From: [REDACTED]
To: [MU1](#)
Subject: 2021/1090 (2) (Phase 1 Layout) - consultee Highways comments
Date: 21 December 2023 07:26:45
Attachments: [image001.jpg](#)
[image002.png](#)
[image004.png](#)
[image003.png](#)
[image006.png](#)
[image007.png](#)
[image008.png](#)
[image009.png](#)
[image010.png](#)
[image011.png](#)
[image012.png](#)
[image013.png](#)
[image014.png](#)
[image015.png](#)
[image016.png](#)
[image005.jpg](#)

Subject: FW: 2021/1090 (2) (Phase 1 Layout) - Land south of Barugh Green Road and east of Higham Common Road Barnsley

Many thanks for consulting Highways Development Control in respect of the recent resubmission. Initial consultation was received on 25th October 2023, with further highway related information received following that date. Comments are provided in relation to the revised site layout plan ref 20-CL4-SEGB-BWP1-02 Rev O for the Phase 1 residential development for which full planning permission is sought. These comments are without prejudice to any further comments on other key elements of this hybrid application.

I refer to the above planning application and specifically in respect of the revised site layout plan ref 20-CL4-SEGB-BWP1-02 Rev M

BARNSELY WEST PHASE 1 | MATERIALS, BOUNDARY TREATMENT & SURFACING PLAN

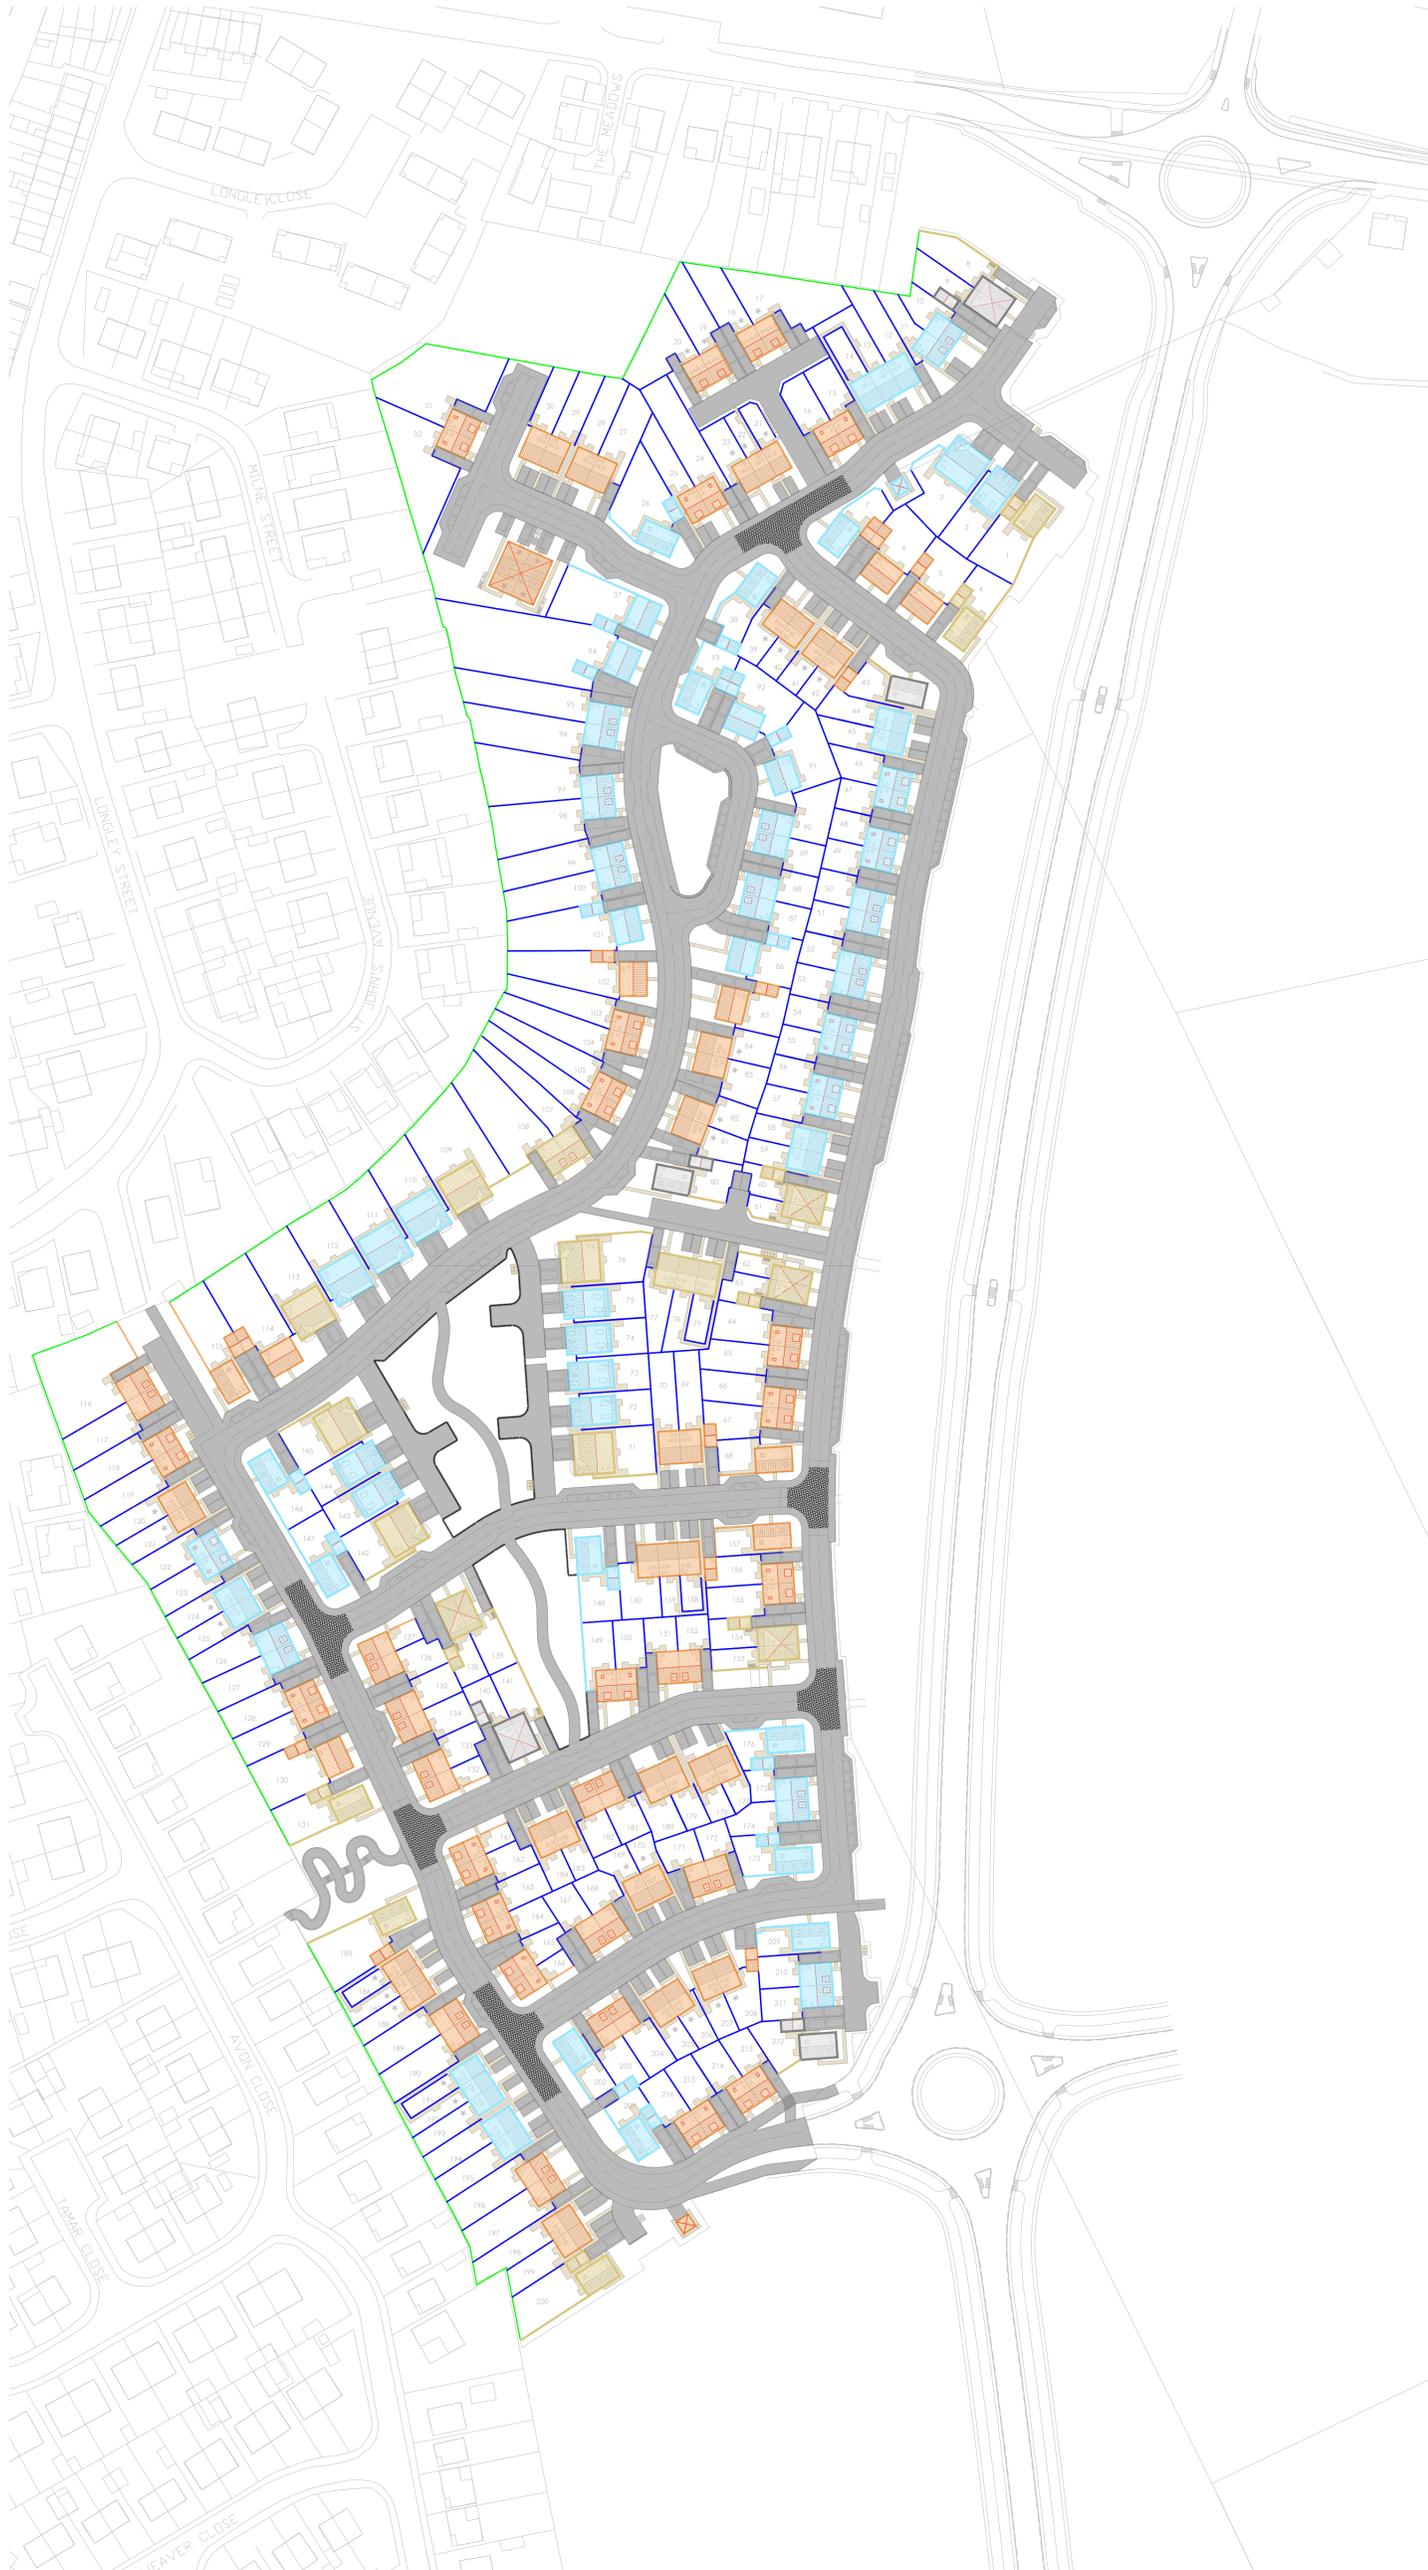
The 1.2m high railing boundary treatments edging the shared private drives serving plots 72-74; 75-77; 140-142; 143-146; and 149-153 together with adjacent boundary treatment to rear of footway adjacent impede visibility at a drivers eye height of 1.05m and therefore not acceptable.

This comment has not been addressed and therefore the comment remains applicable, noting that line type has now changed on the key shown on the site layout plan. The layout is to be amended accordingly.
